15 West Street Permit# 2017-00425

This email is to serve as our response to your review of the FPE code analysis and to address all of the renovations that need to be made to bring 15 West St into compliance with city requirements. I will be addressing each of your concerns point by point below:

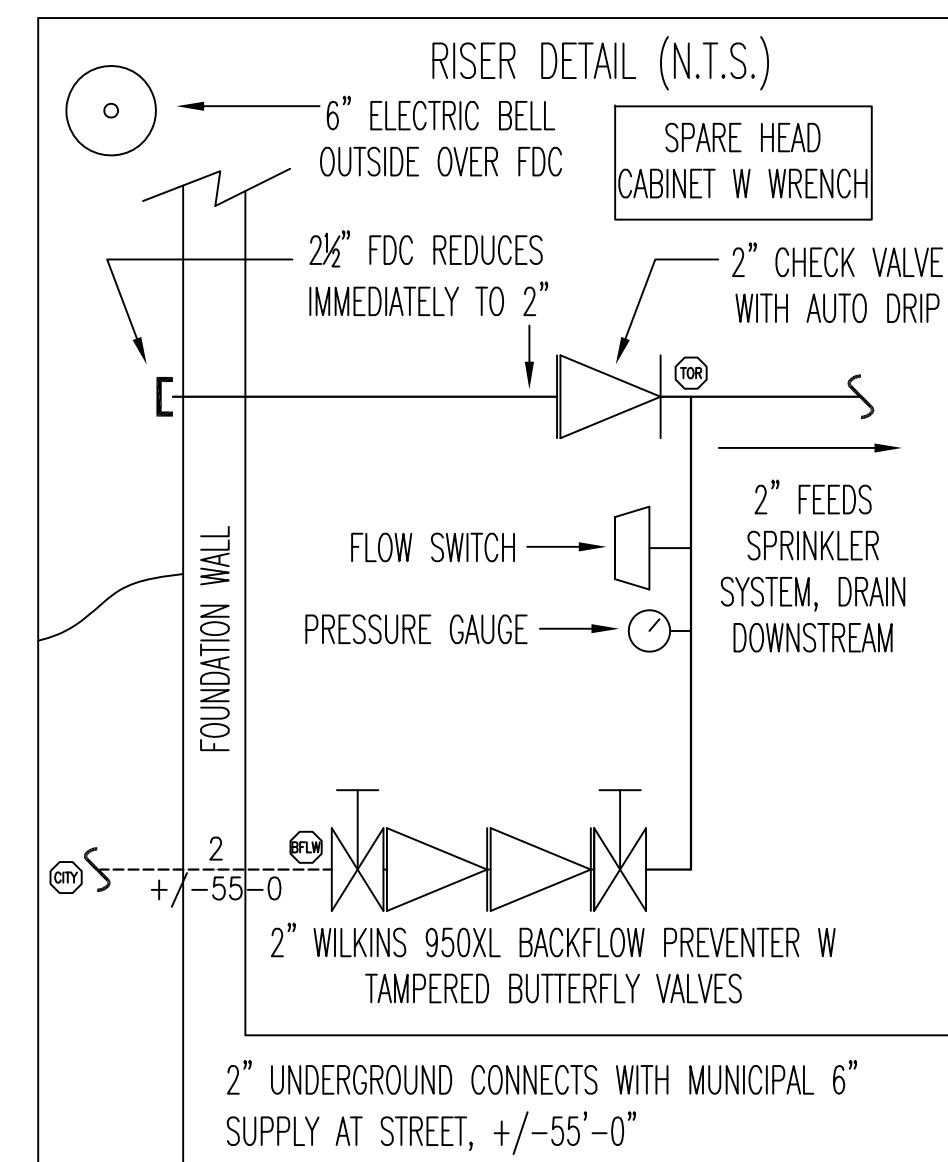
- We have contracted with Life Safety Fire Protection to complete the installation of a 13R sprinkler system. Please see his attached plans.
